# **M60/M62/M66 Simister Island Interchange**

**TR010064**

## **7.13 APPLICANT'S RESPONSES TO RELEVANT REPRESENTATIONS**

<b>Version</b>	<b>Date</b>	<b>Status of Version</b>
P01	24 September 2024	Deadline 1

**Plate 2.5 Conceptual site model for The Hills South**

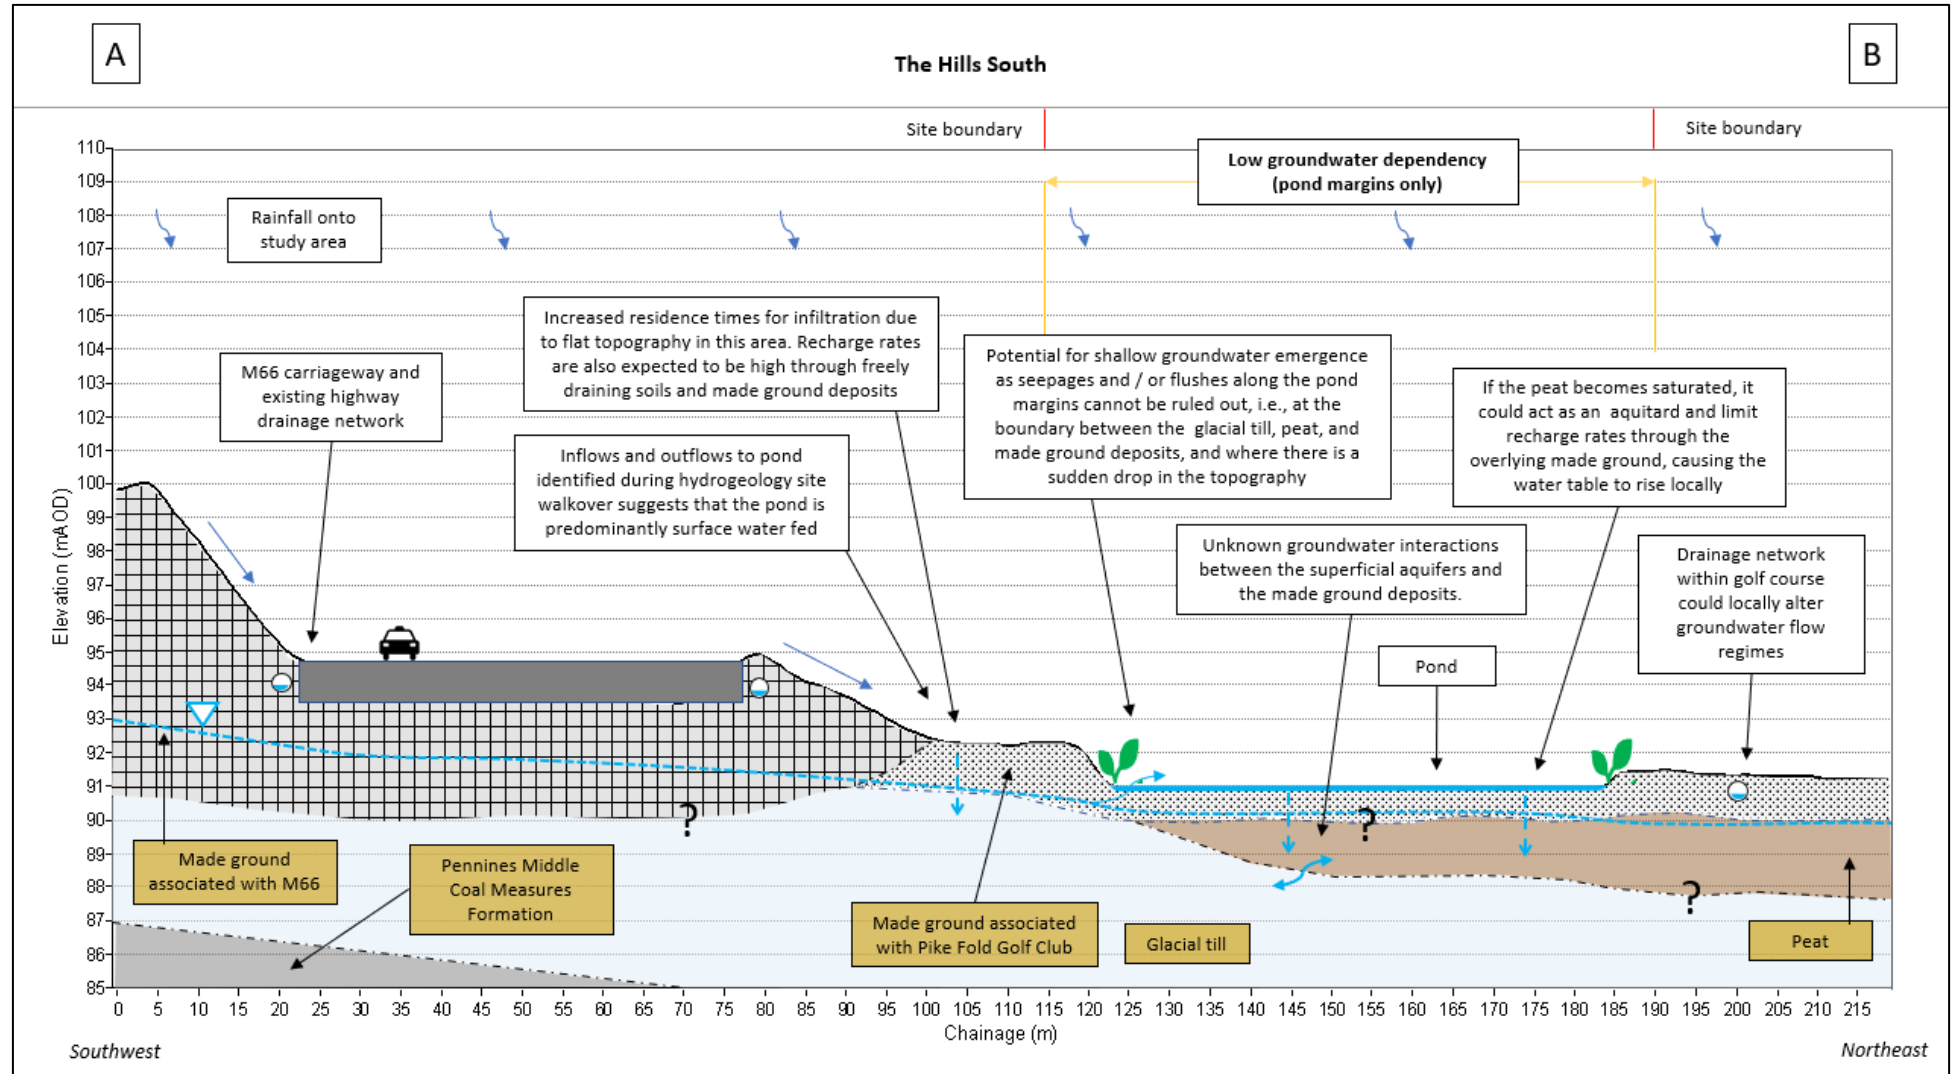
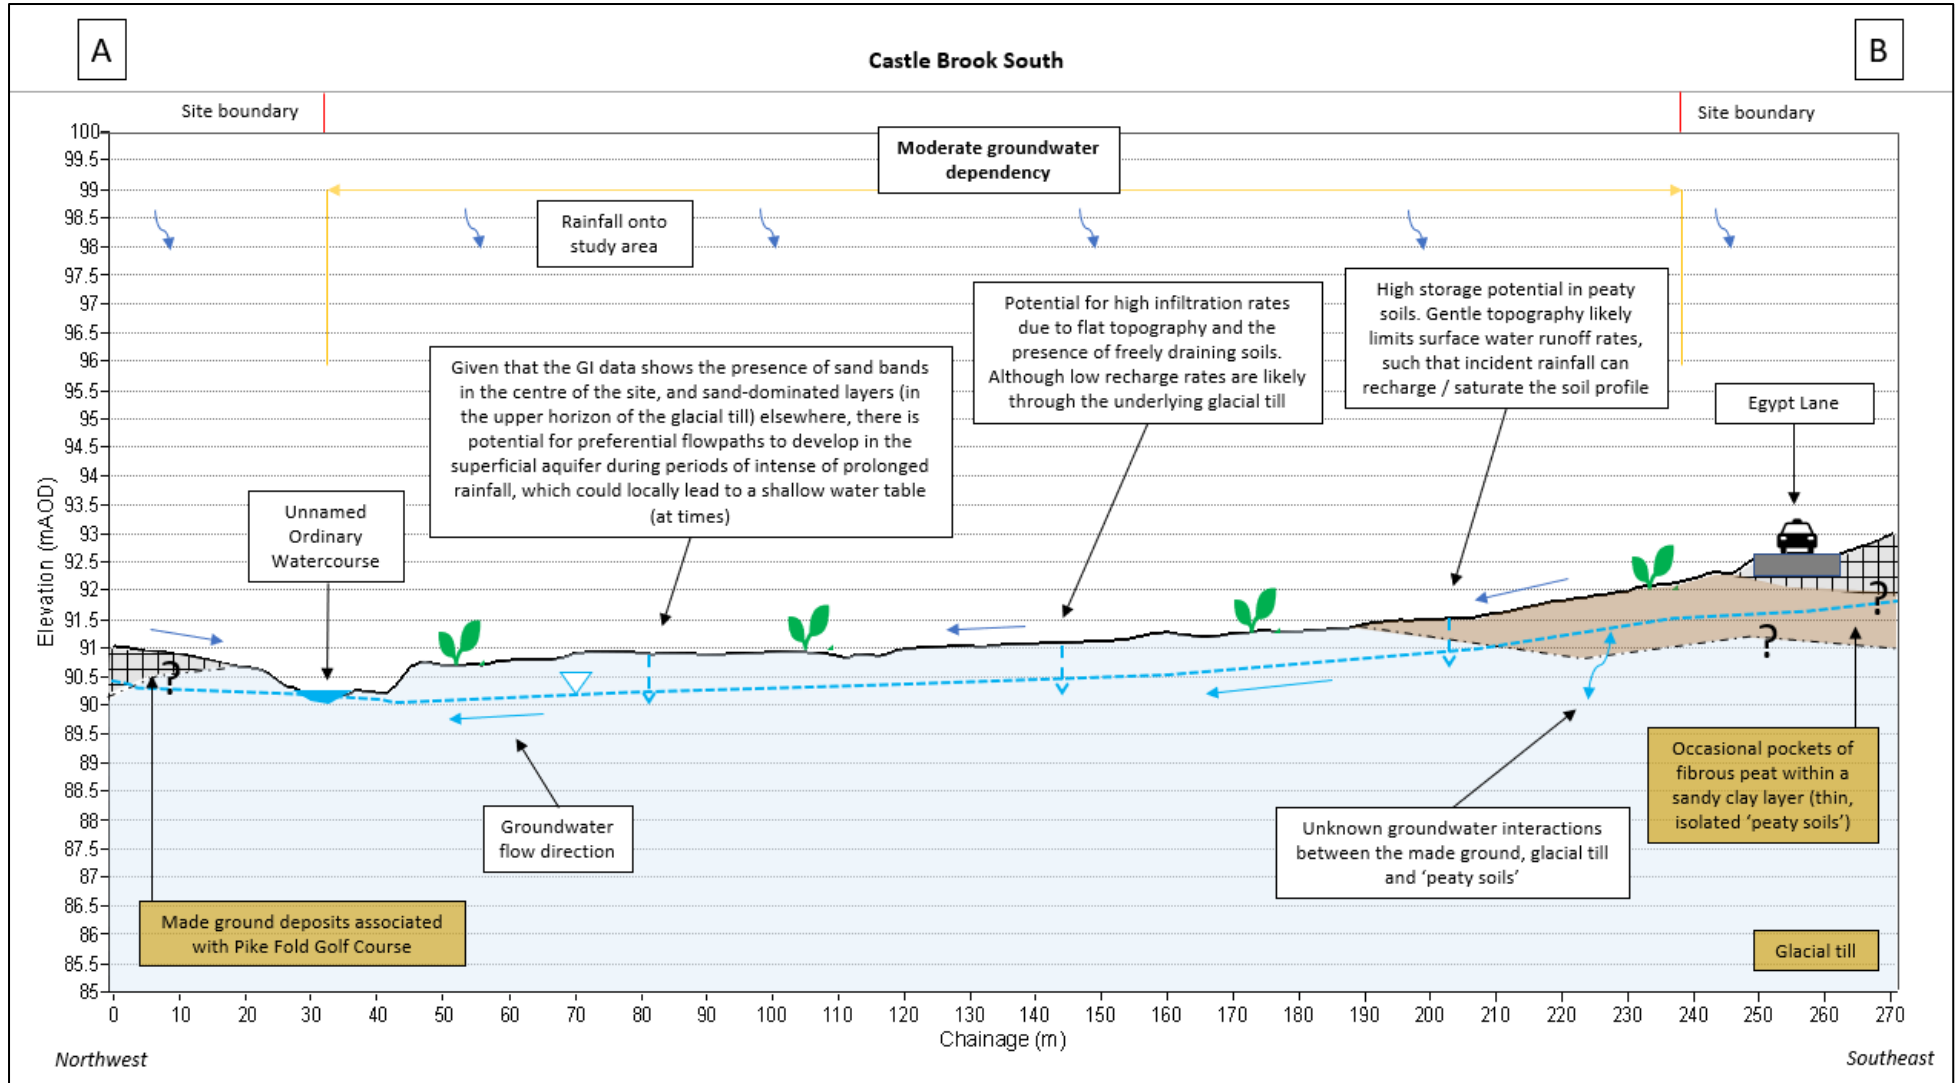
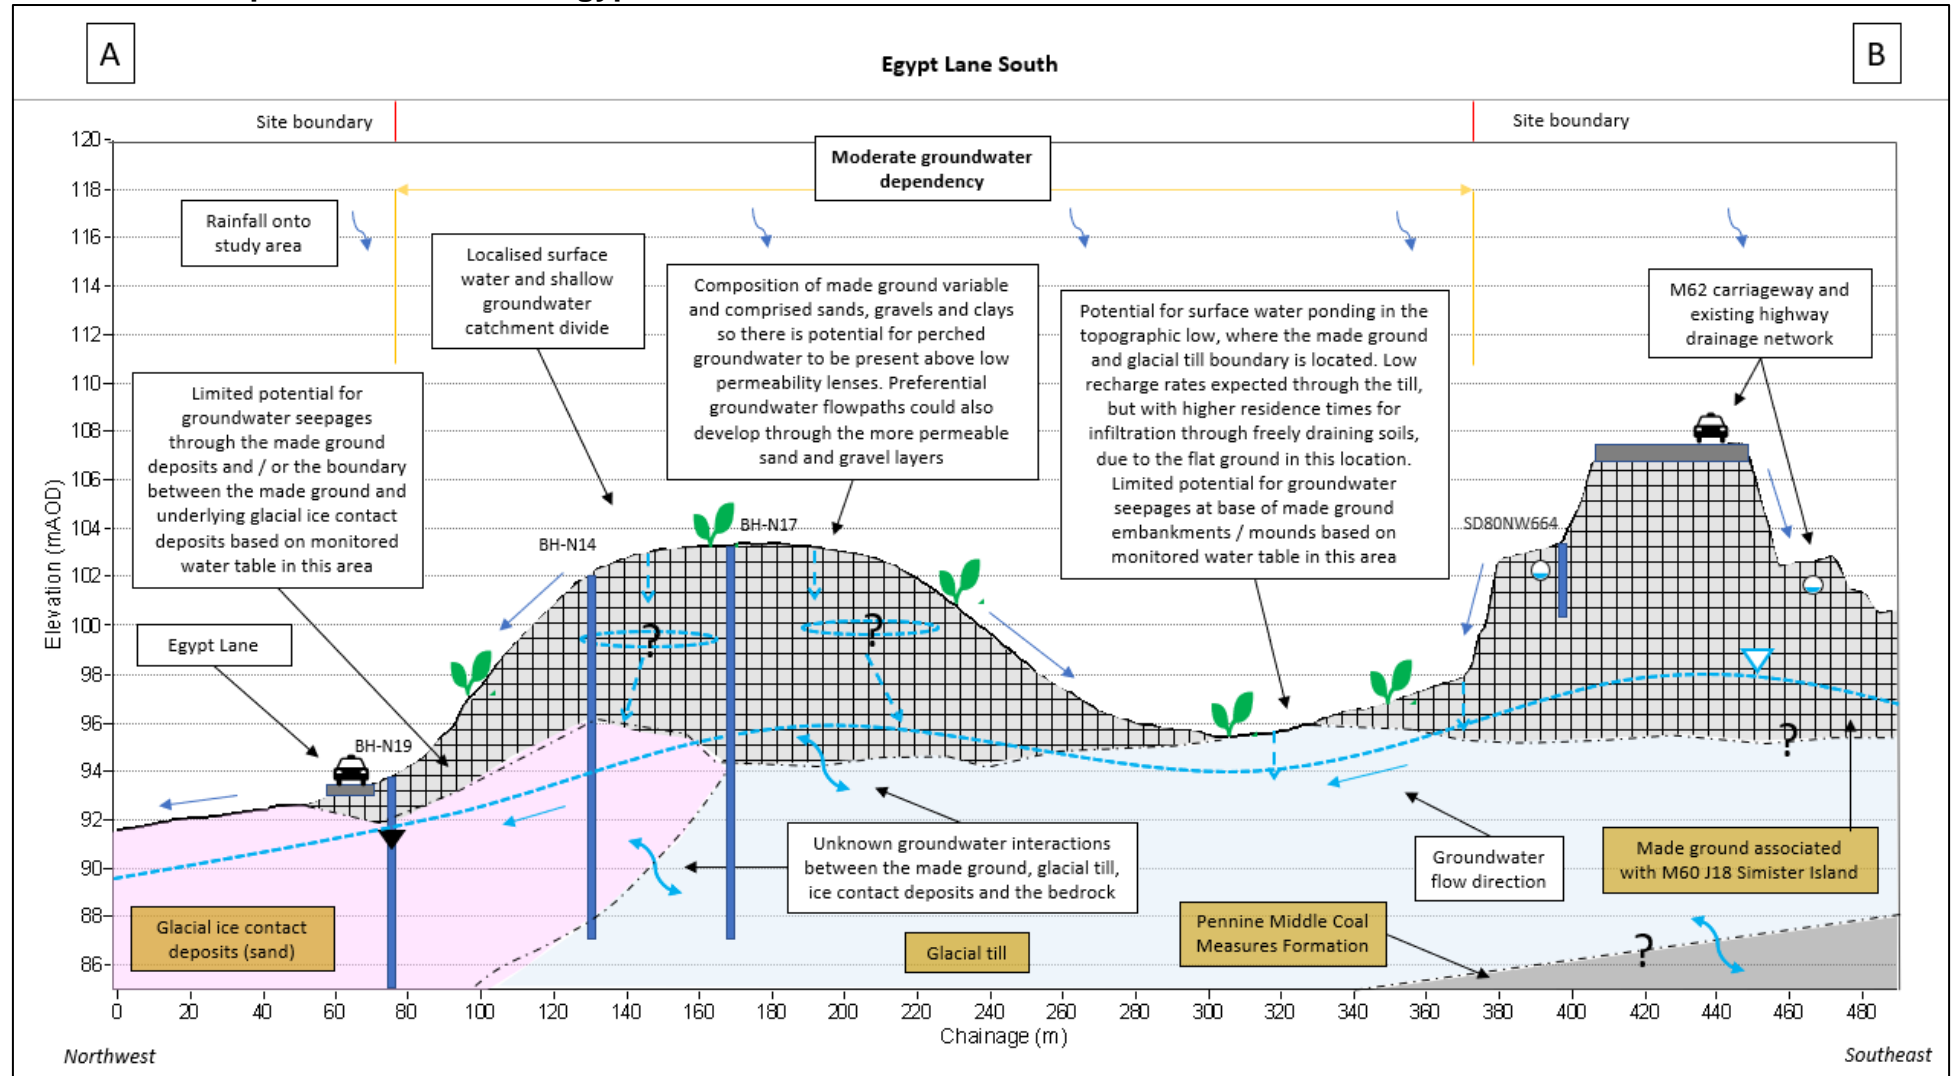
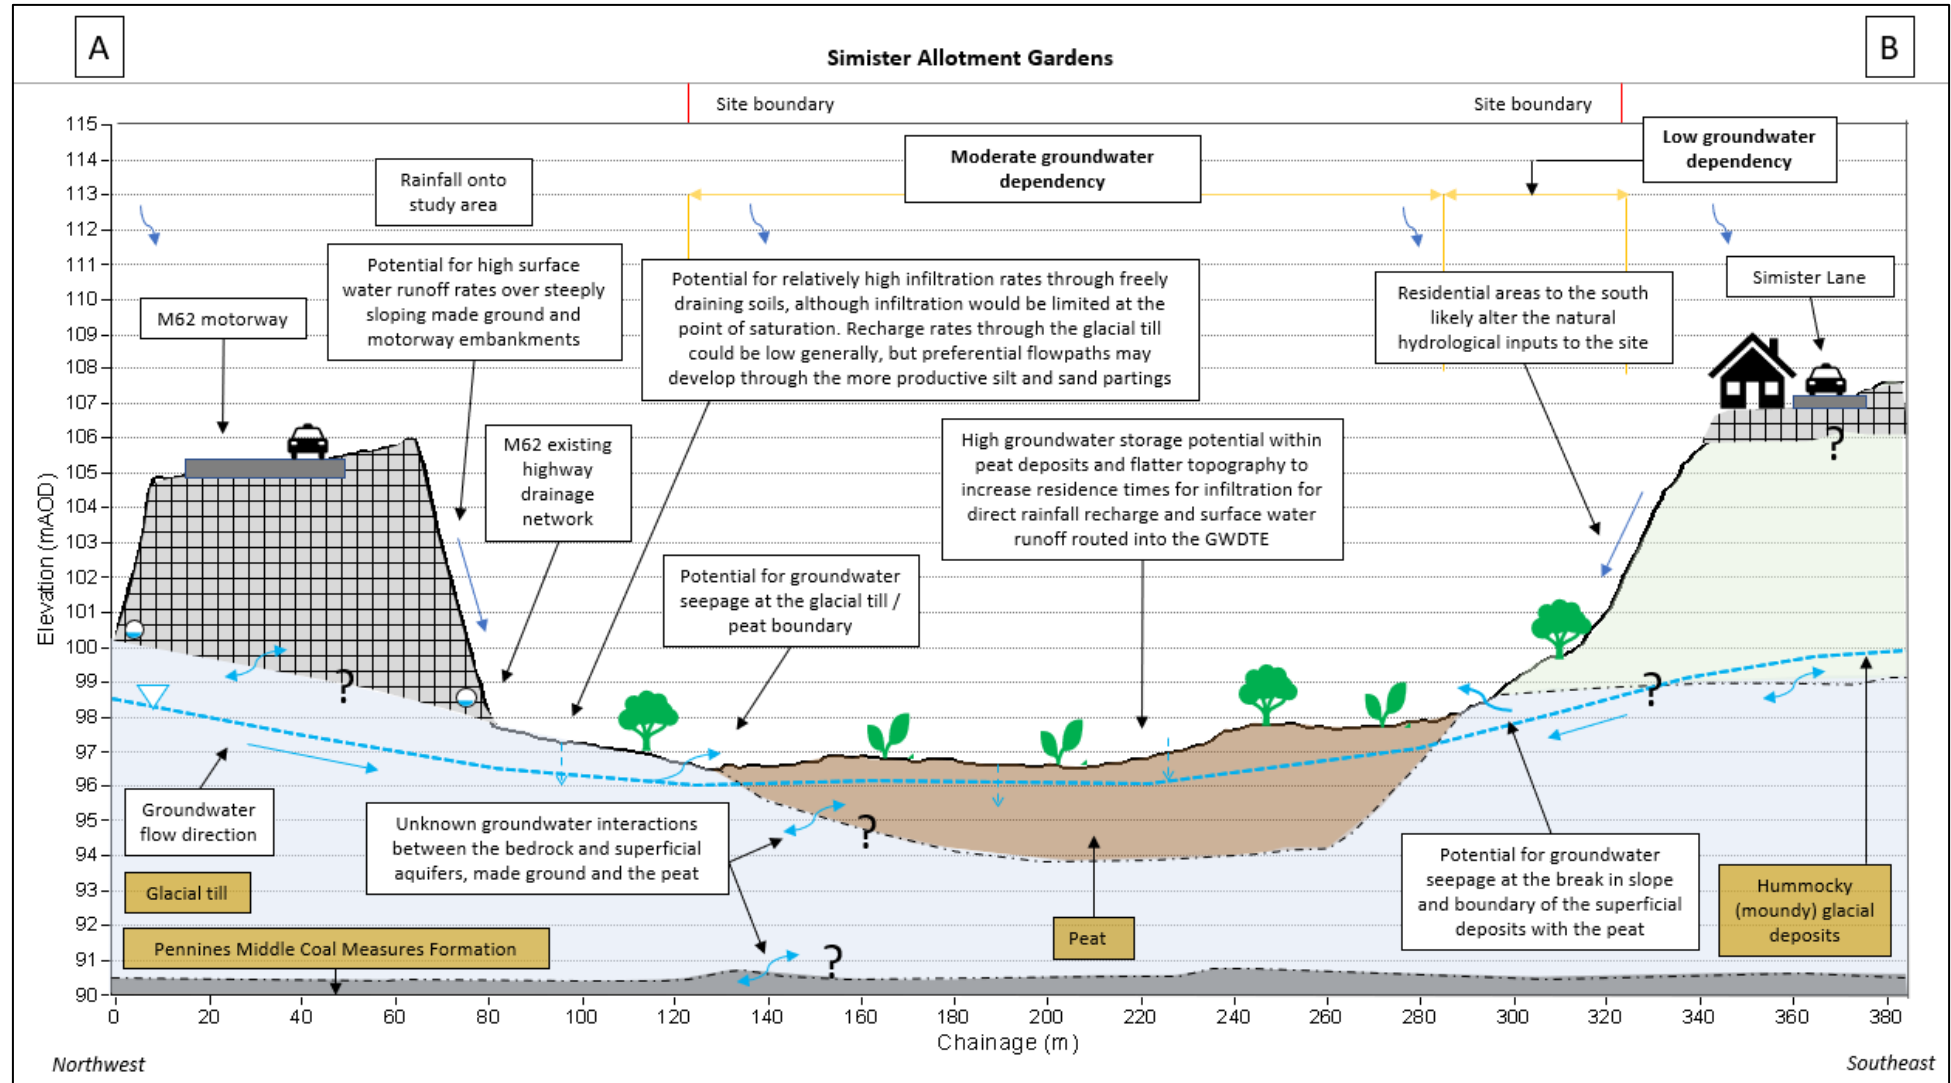
RR-004e	<i>The conceptual models have shown that there are connections with the groundwater dependent terrestrial ecosystems as shown in the report. The HERWAT assessment considered in Appendix 13.2: Water Quality Assessment Report of the Environmental Statement Appendices (TR010064/APP/6.3) does not look at impacts to groundwater. If any changes are made and discharges are to be made to groundwater, then a water quality assessment must be completed in line with the SUDS manual (C753) to determine the risks and mitigations required for groundwater quality. This is especially important because of the presence of nearby groundwater dependent terrestrial ecosystems.</i>	Please refer to the response provided in the agreed Statement of Common Ground with the Environment Agency [TR010064/APP/7.11].
RR-004f	<i>We note under Chapter 9 (Geology and Soils) of the Environmental Statement that there is an intention to produce a Detailed Quantitative Risk Assessment (DQRA) to establish risks of contamination from the proposed development to 'controlled waters'. Following the production</i>	Please refer to the response provided in the agreed Statement of Common Ground with the Environment Agency [TR010064/APP/7.11].
